Planning Application No: 3/2024/0793

Proposal: Proposed conversion of existing garage and workshop to two-storey living accommodation and integral garage. Alterations to include new slate roof and timber cladding.

Location: 1 Ferry Butts Garstang Road Chipping PR3 2QJ

The Local Highway Authority have viewed the plans and highway related documents and have the following comments to make:

**TITLE**  
 PROPOSED FLOOR PLANS AND ELEVATIONS  
 SITE PLAN

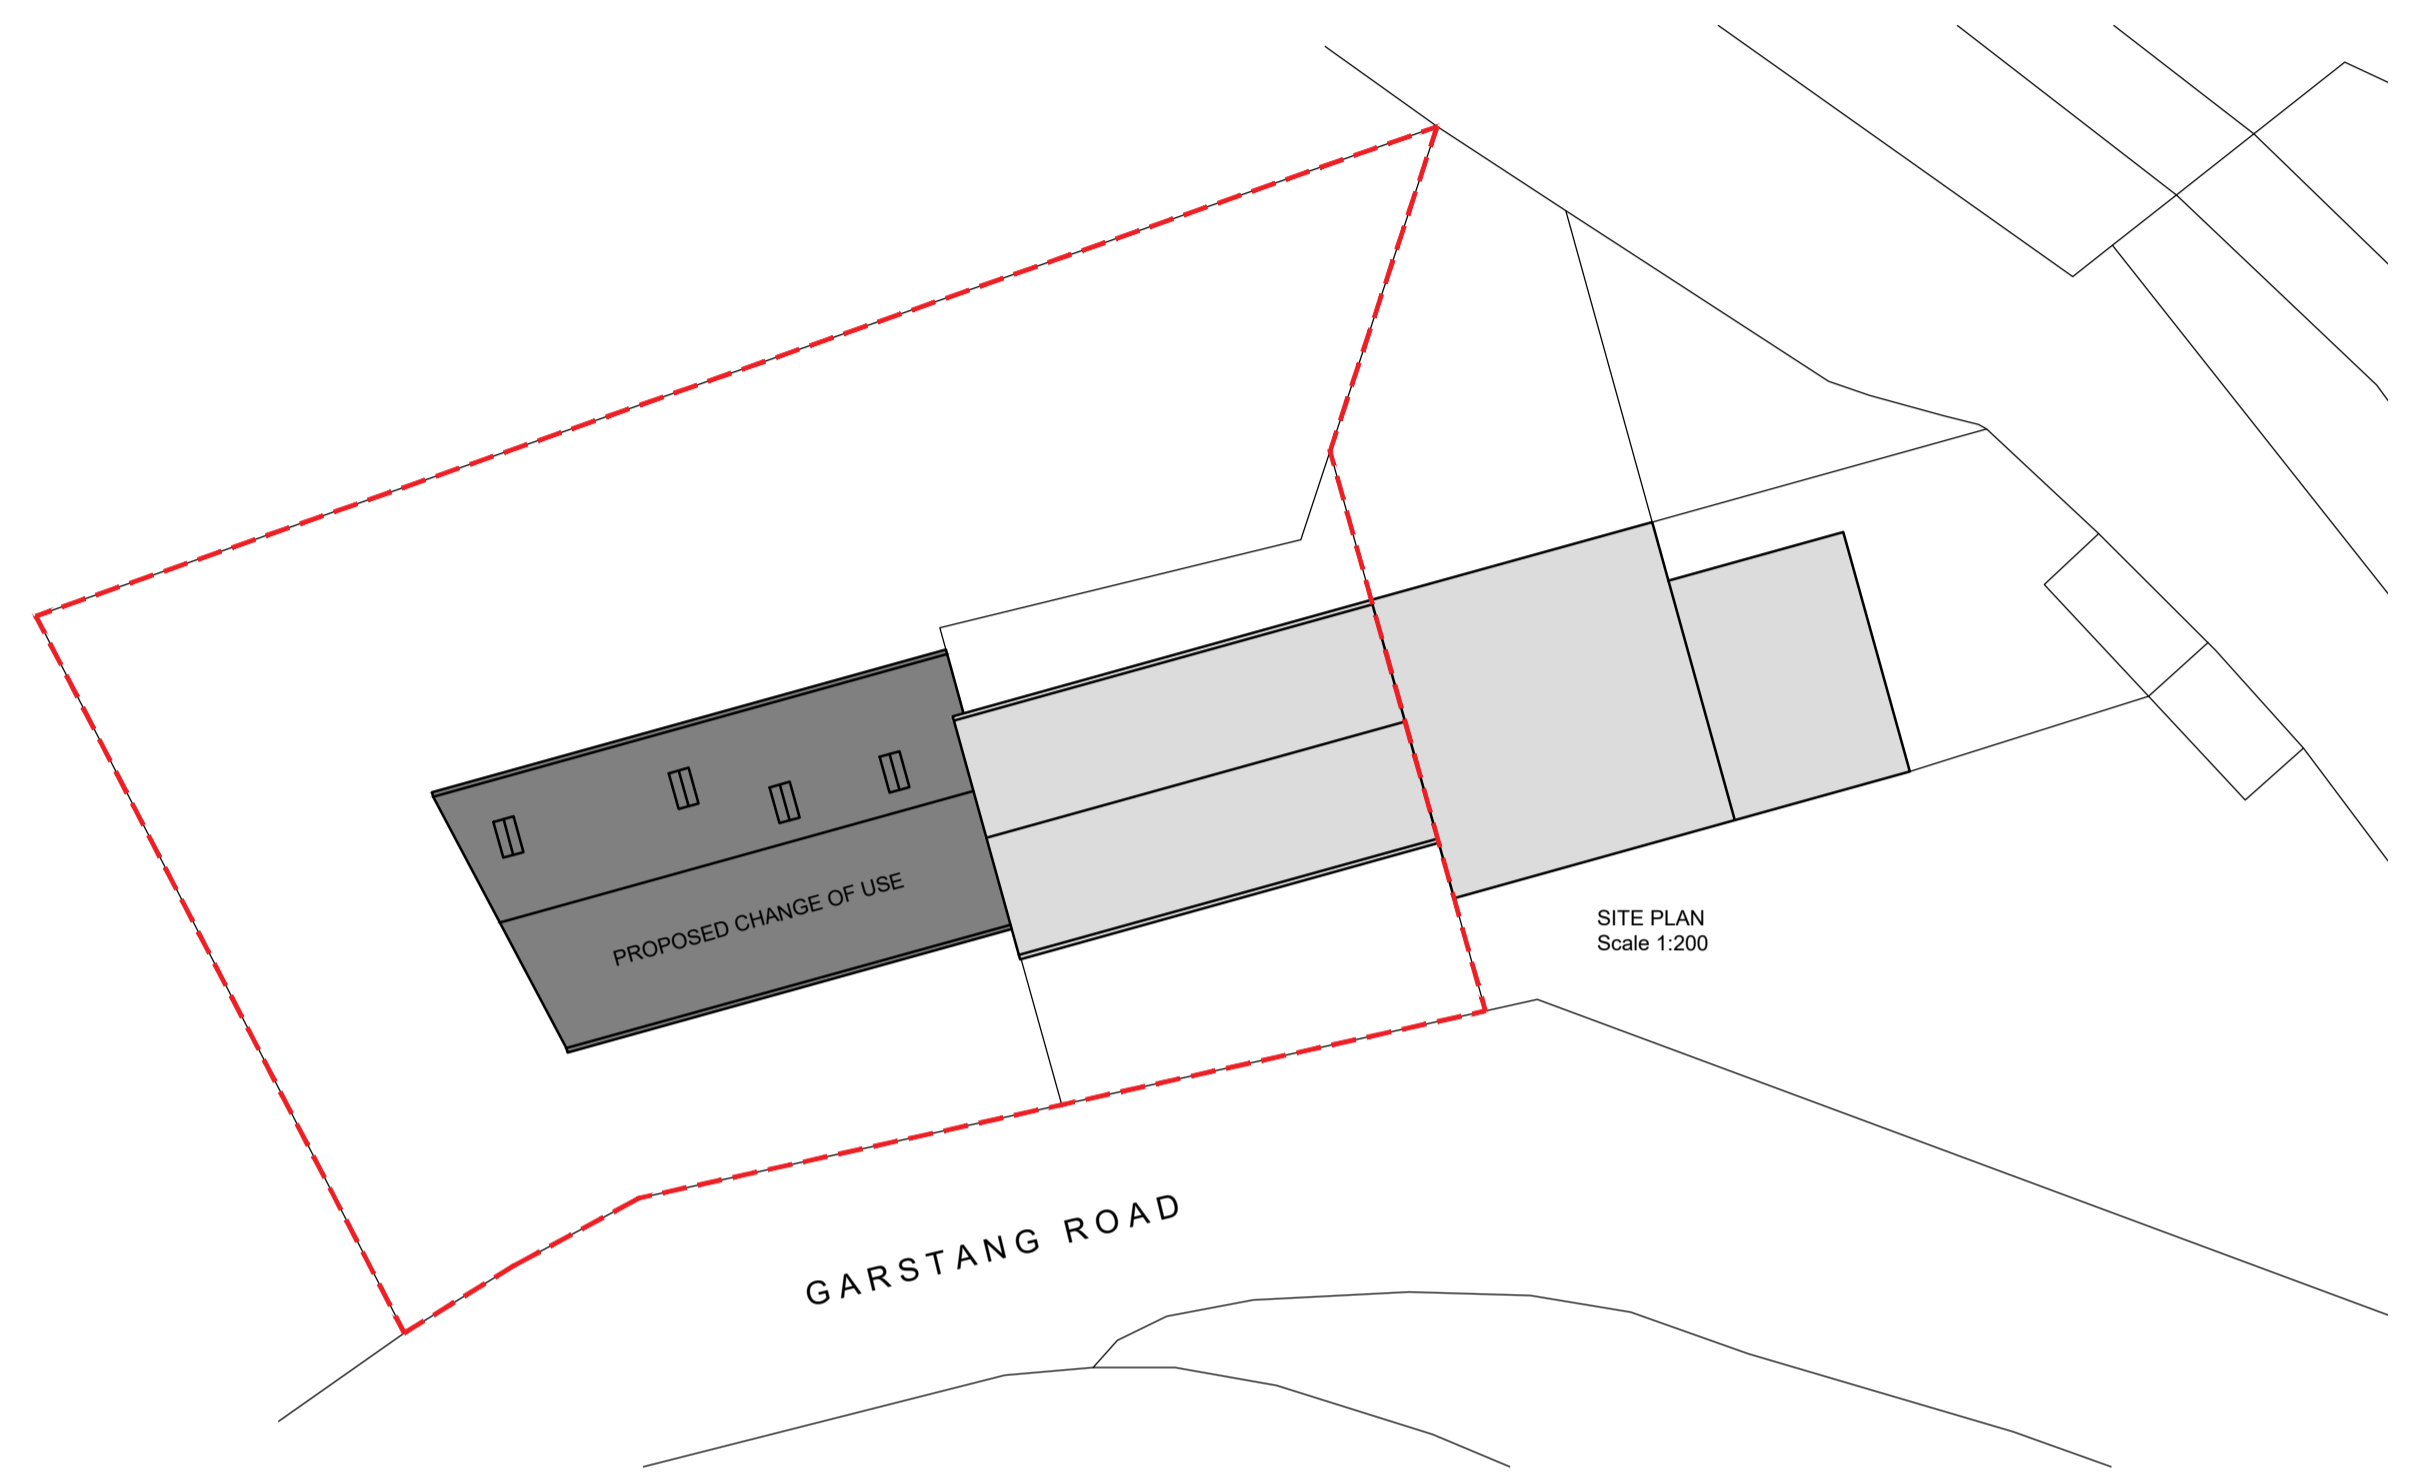
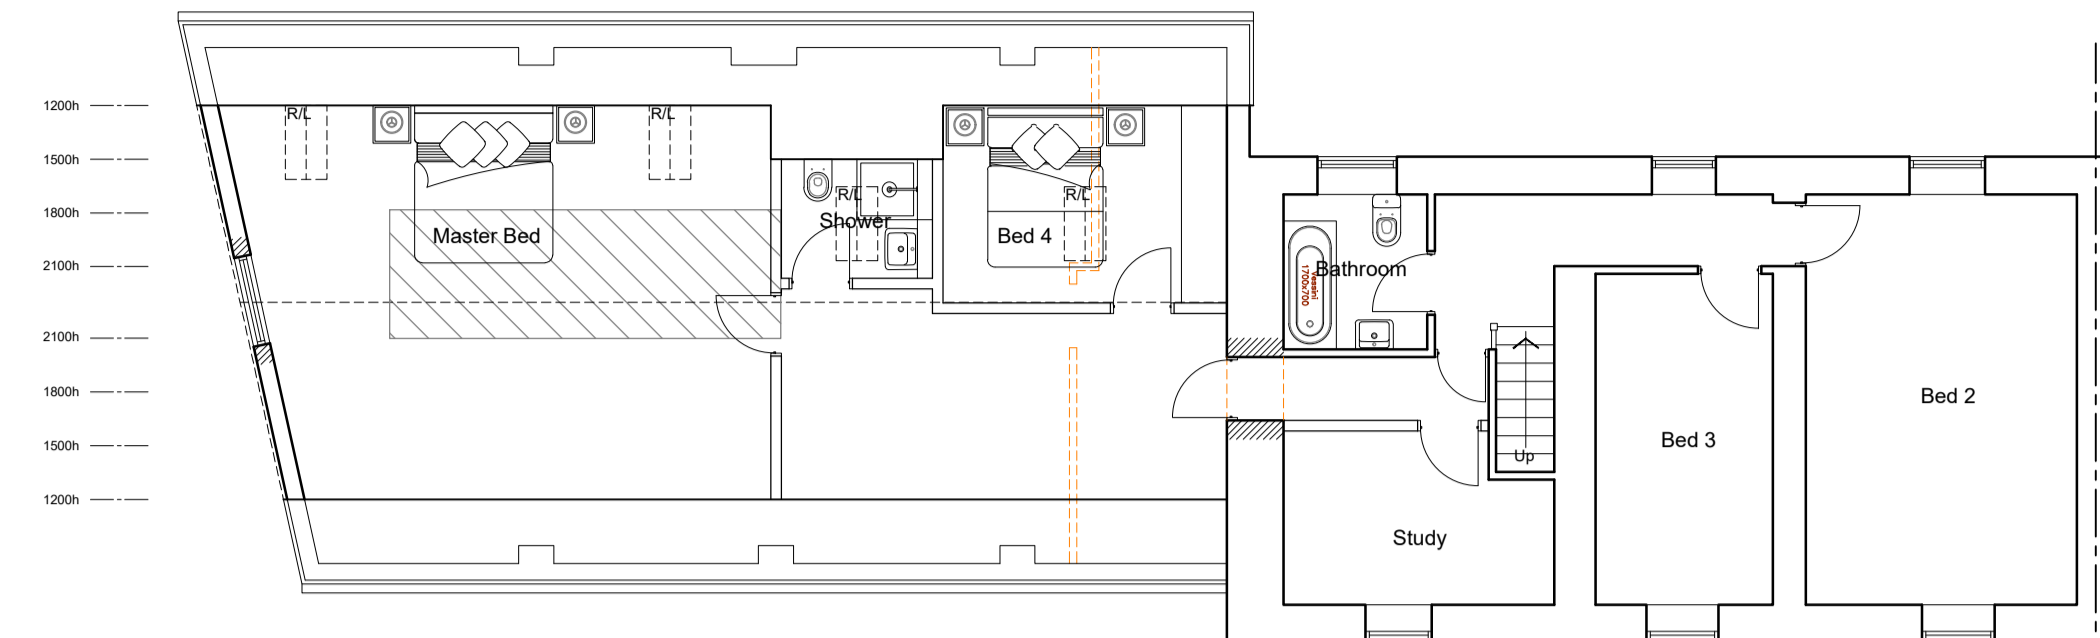
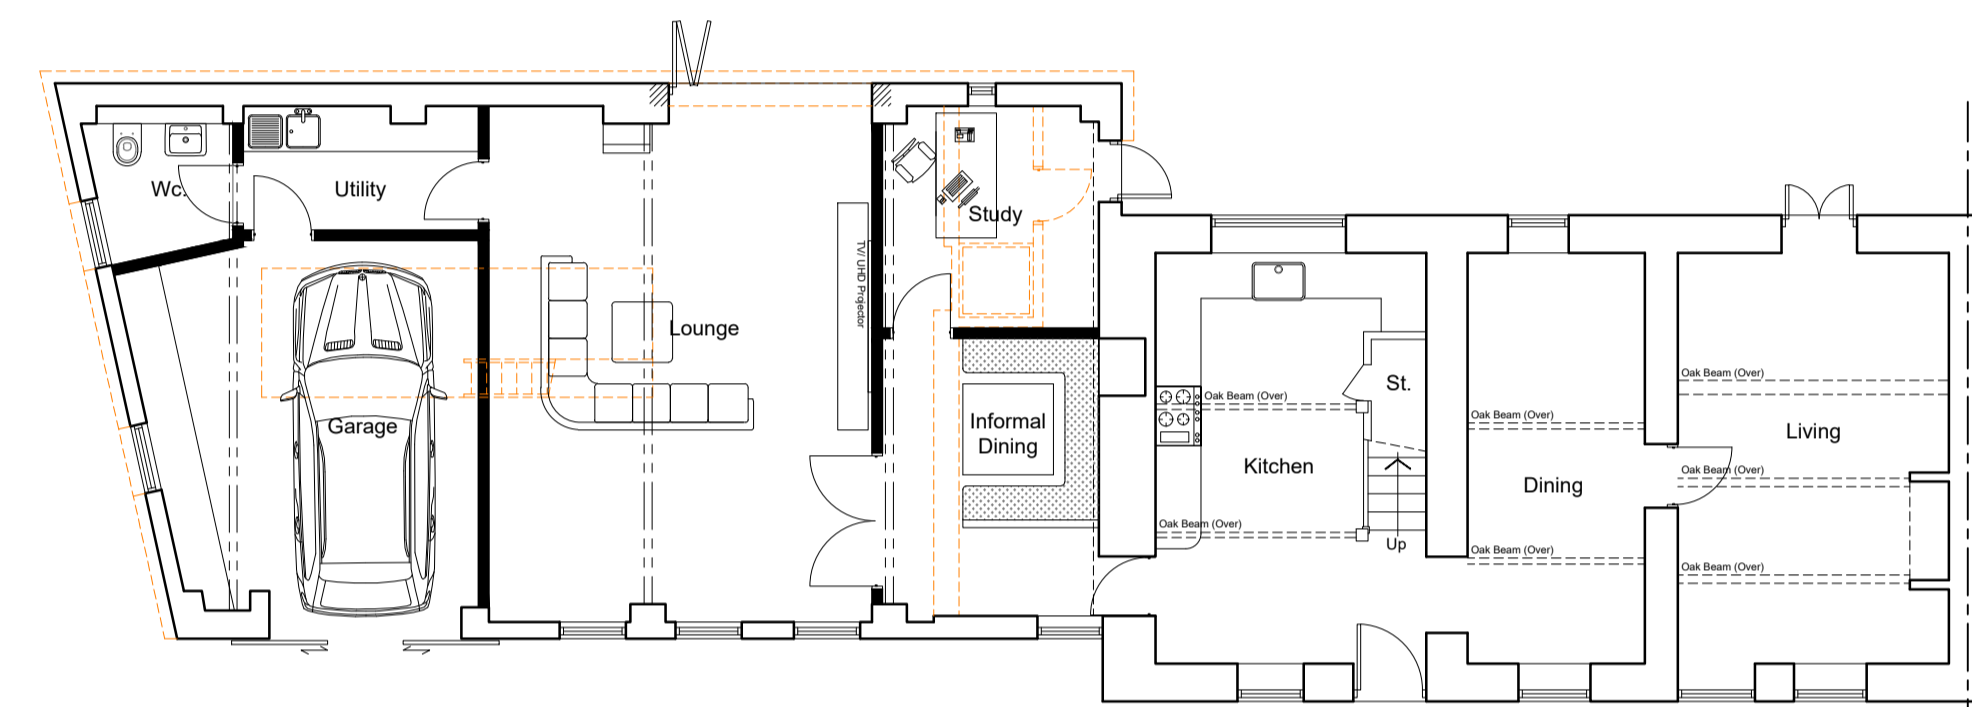
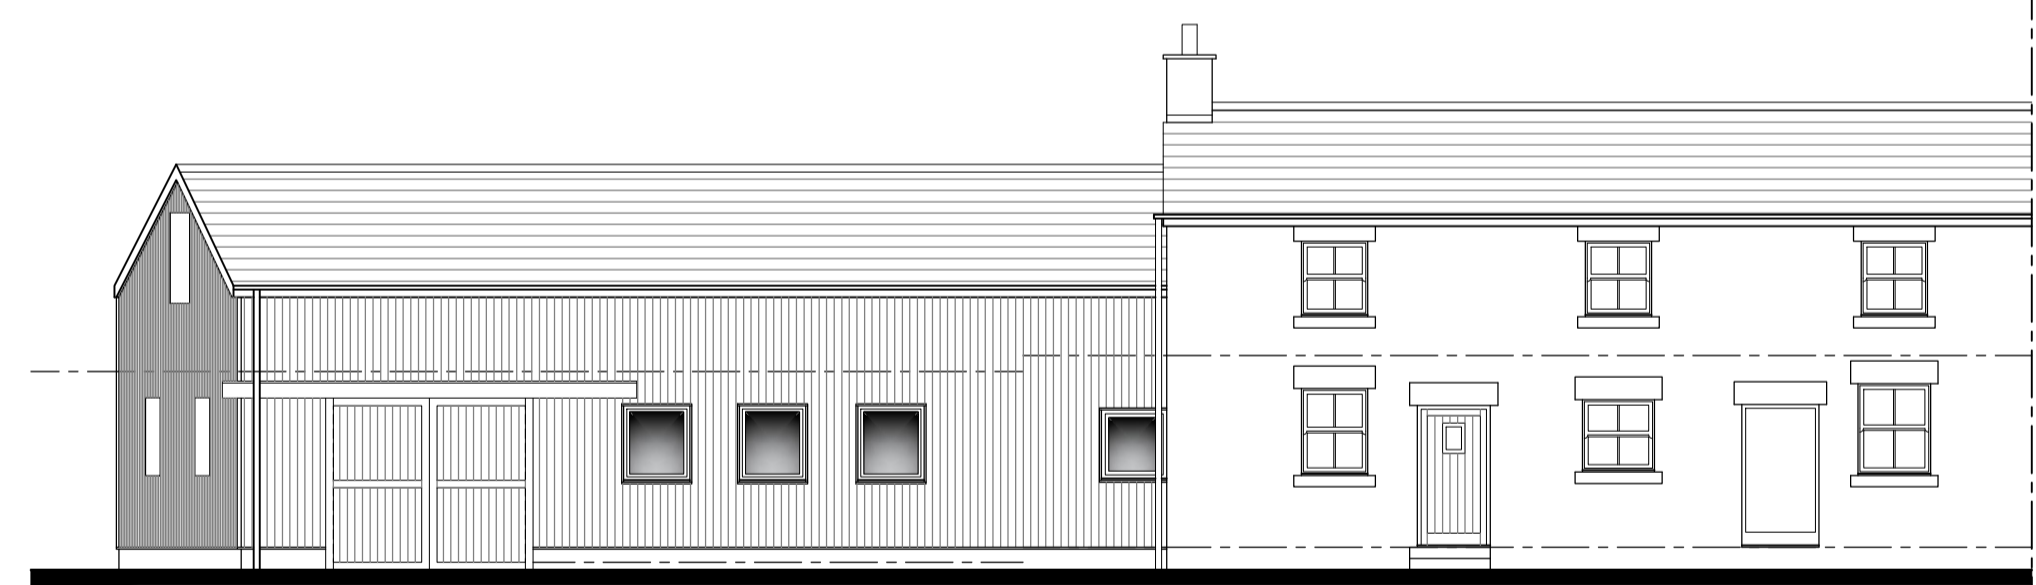
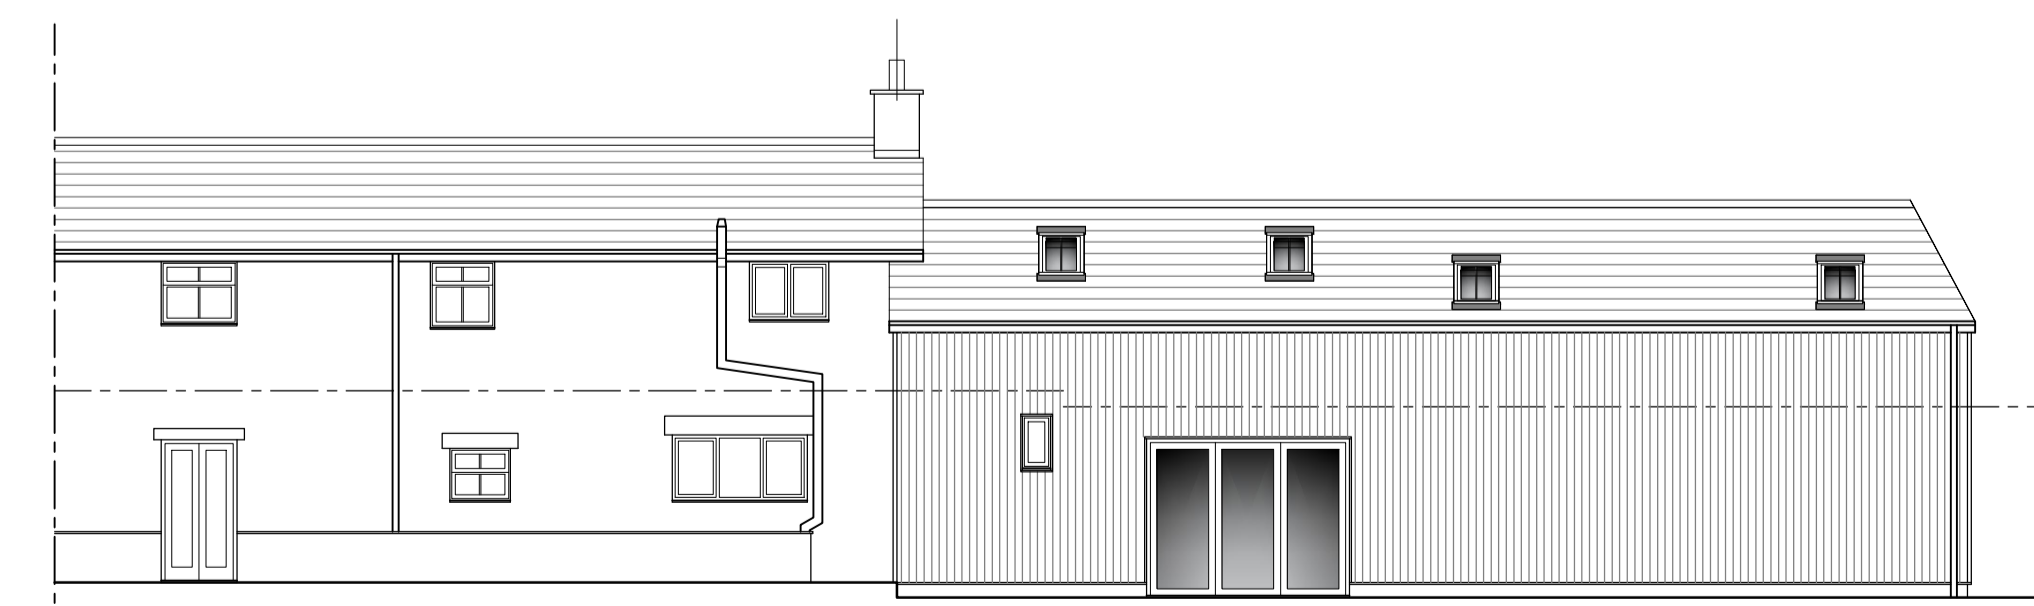
The LHA have reviewed drawing number 2 titled "Proposed Floor Plans and Elevations" and are aware that the number of bedrooms at the site will increase from 3 to 4. For the site to comply with the LHAs parking guidance as defined within the Joint Lancashire Structure Plan, the LHA require 3 car parking spaces to be provided on site.

As part of the parking arrangements, the Design and Access Statement states a minimum of 3 no. vehicles can park off street and there is a turning area to enable vehicles to exit the site in a forward gear, on the existing hardstanding area adjacent to the proposed extension. Therefore, with the site complying with the LHAs parking guidance, the LHA have no objection to the proposal.

1. The development hereby permitted shall not be occupied until such time as the parking and turning facilities have been implemented. Thereafter the onsite parking provision shall be so maintained in perpetuity. REASON: To ensure that adequate off-street parking provision is made to reduce the possibility of the proposed development leading to on-street parking problems locally and to enable vehicles to enter and leave the site in a forward direction in the interests of highway safety and in accordance with the National Planning Policy Framework (2023).
